MIDTOWN COLLECTION AT HANNAH RIDGE FILING NO. 3 COUNTY OF EL PASO, STATE OF COLORADO OVERLOT GRADING & EROSION CONTROL PLAN

EPC STORMWATER REVIEW COMMENTS IN ORANGE BOXES WITH BLACK TEXT (Note that comments on SH 2 are the same comments submitted to EDARP on 11/16/2021 for EGP207)

EGP-20-007

MIDTOWN COLLECTION AT HANNAH RIDGE FILING NO. 3 OVERLOT GRADING & EROSION CONTROL PLAN TITLE SHEET DESIGNED BY KRC SCALE DATE 09/20/21 DRAWN BY KC (H) 1"= NA SHEET 1 OF 5 CHECKED BY (V) 1"= NA JOB NO. 1116.35

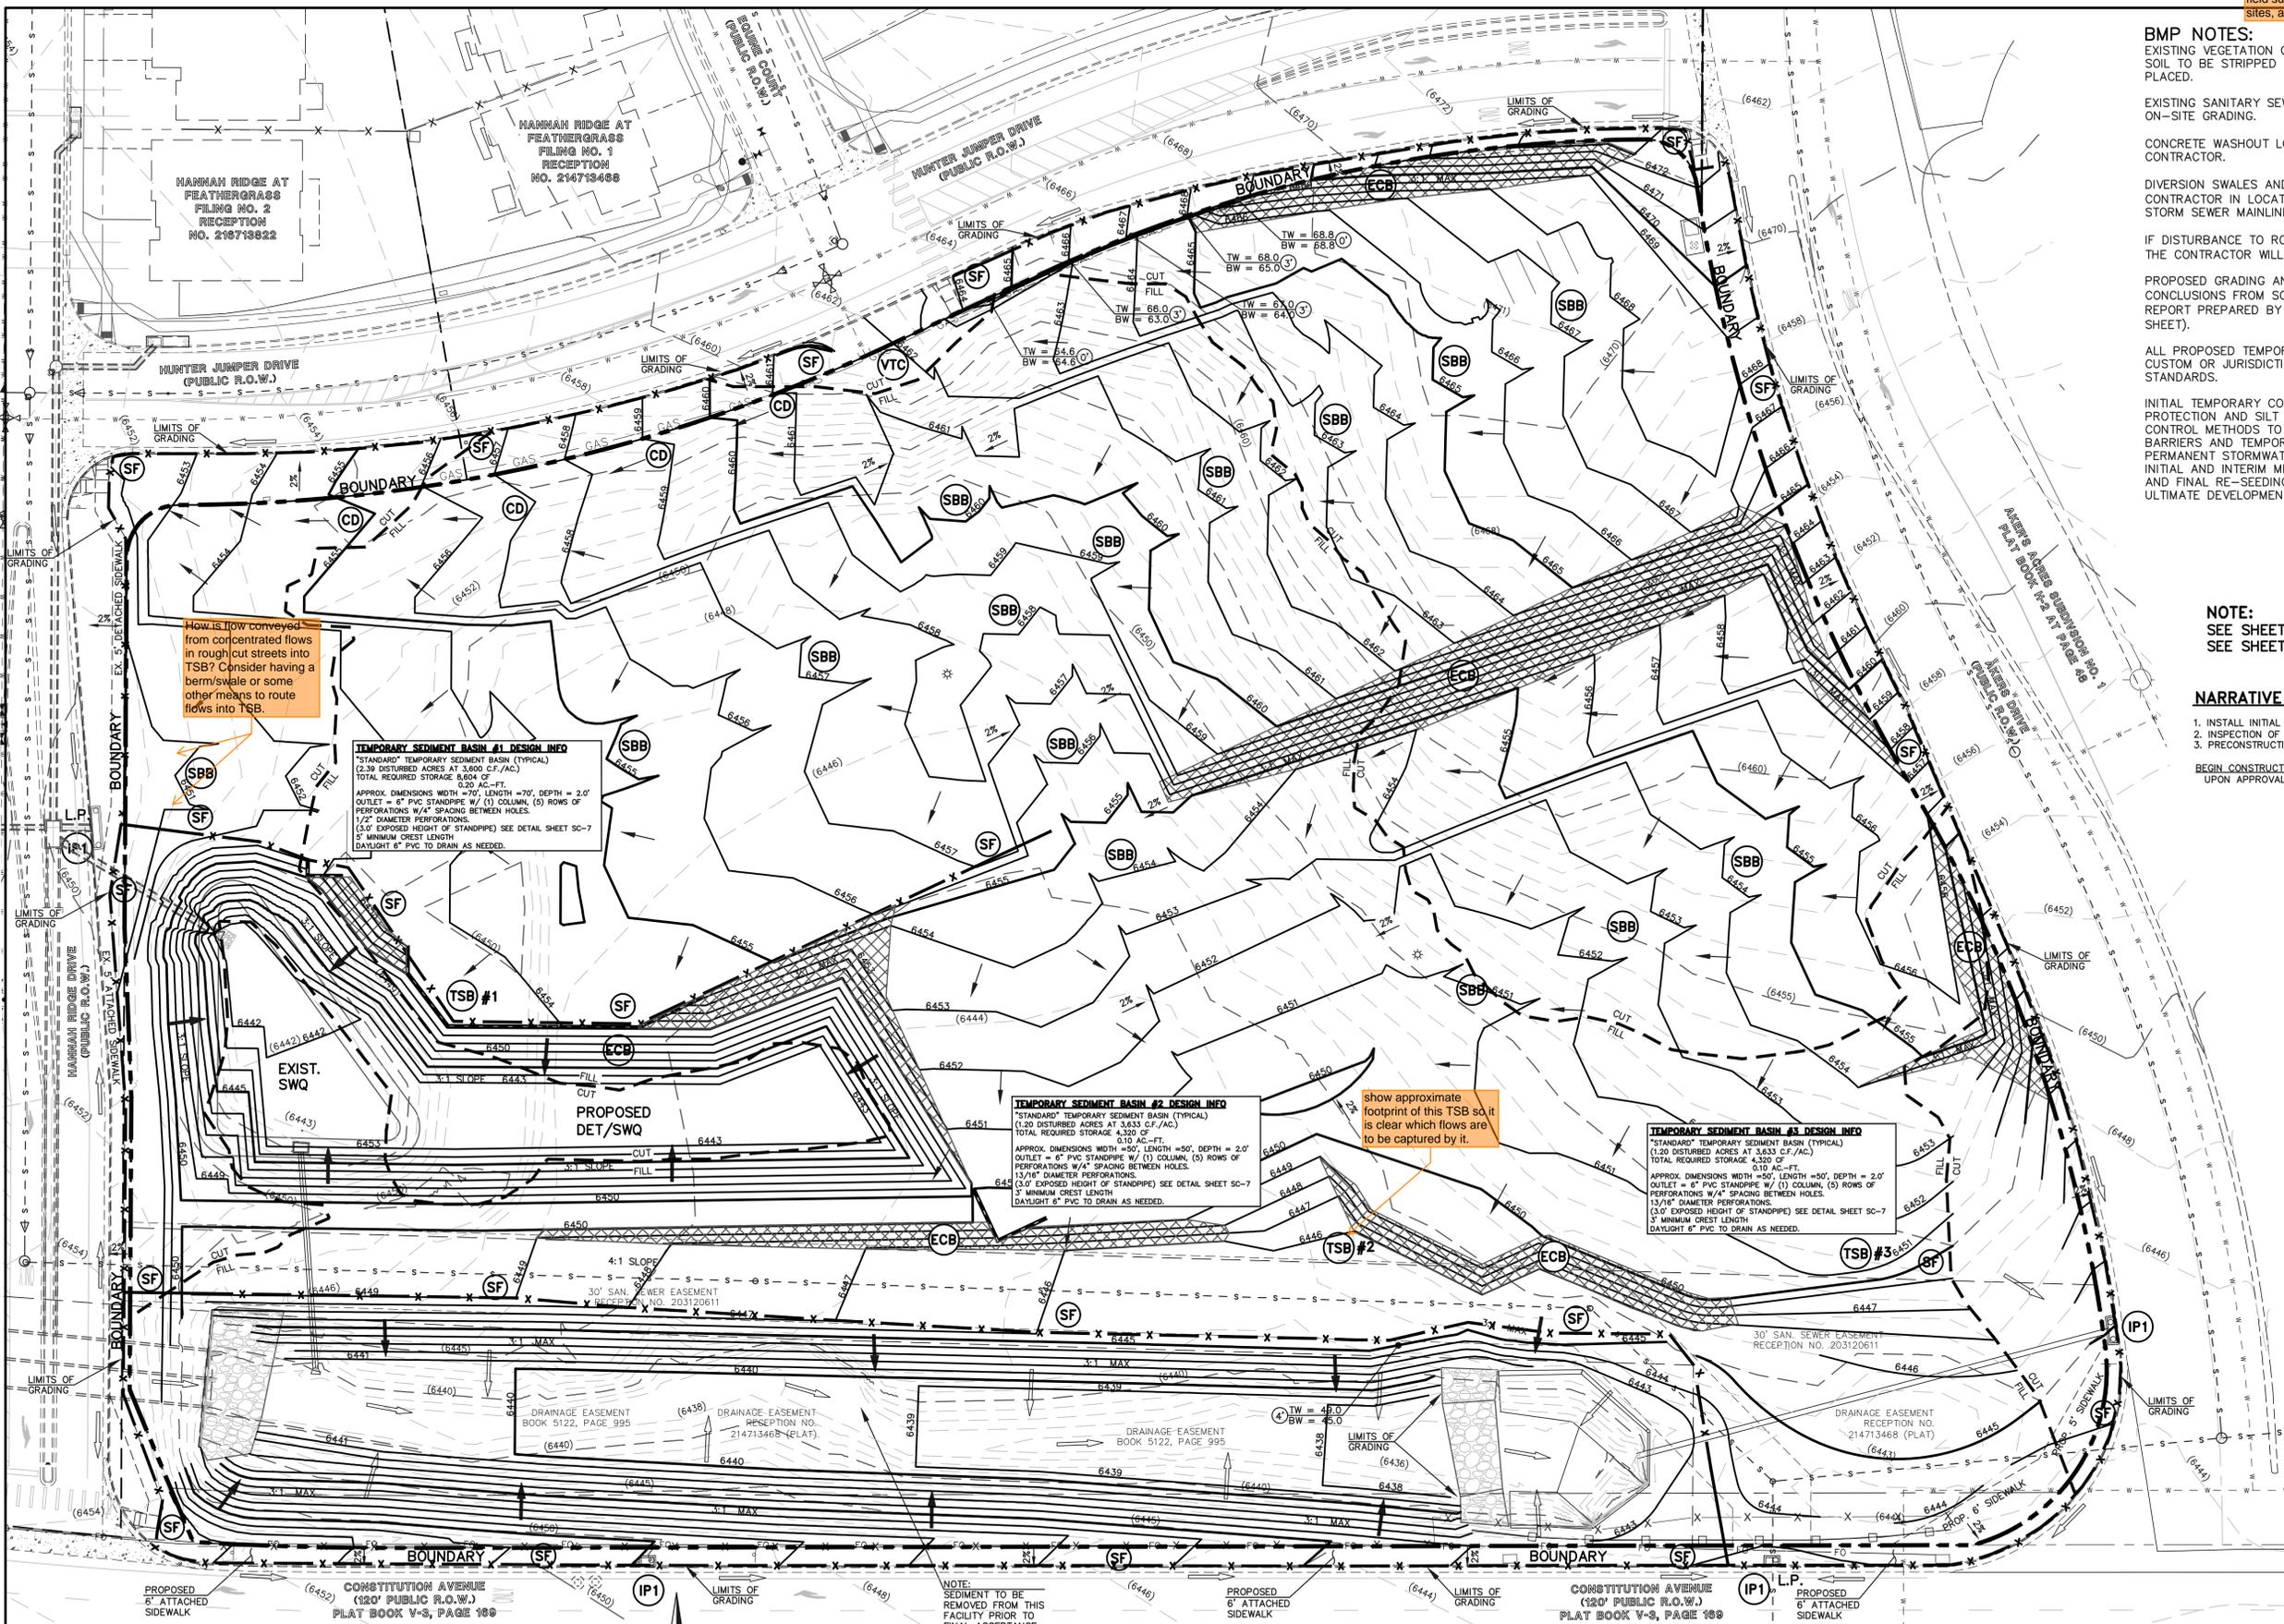
How is flow conveyed from concentrated flows in rough cut streets into TSB? Consider having a berm/swale or some other means to route flows into TSB.

show approximate footprint of this TSB so it is clear which flows are to be captured by it.
